RE: J156455 Tweed Valley Hospital Development – Stormwater Management - Ecological Response to DPE

Greencap has reviewed the letter provided by Robert Bird Group (Ref: CR: KO LTR/C 19005C; 9 April 2019), with respect to stormwater quantity and quality. We note that the one of the OEH requirements referenced in the letter from Robert Bird Group is that:

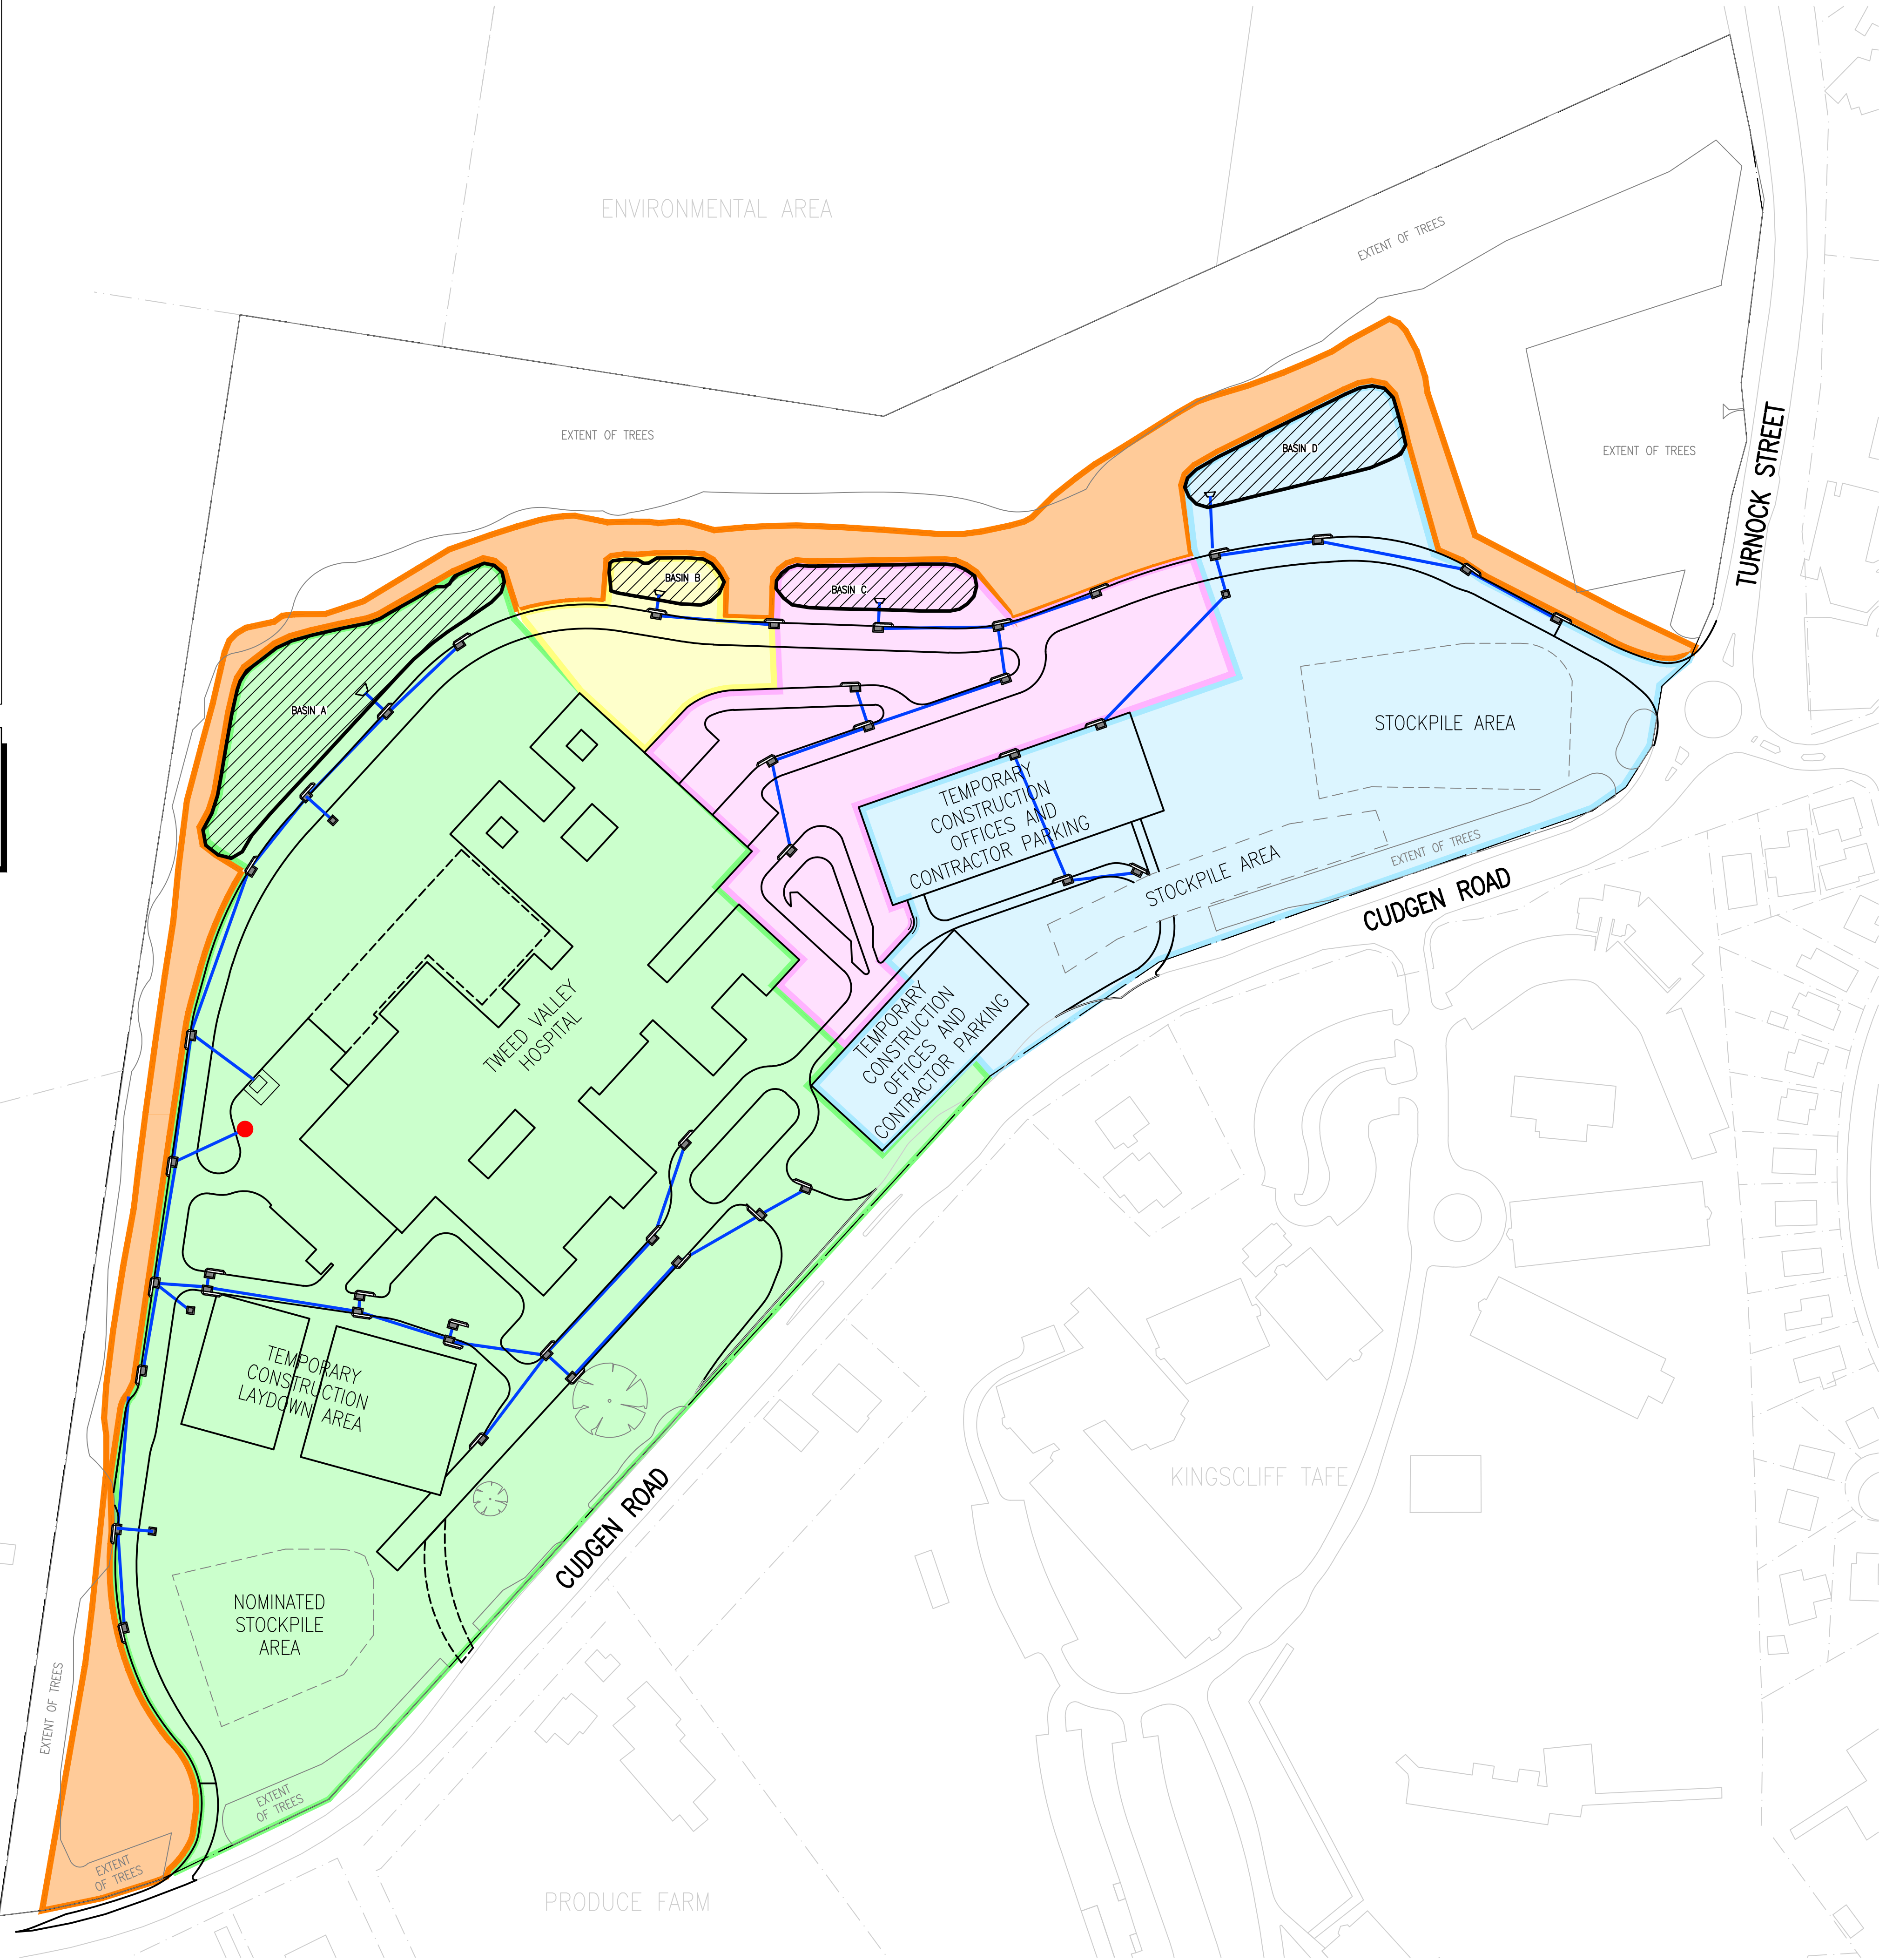
Additional controls and contingency measures should be developed for potential failure or overload of the detention basins. Consideration should also be given to impacts on groundwater as a result of infiltration of nutrient rich stormwater.
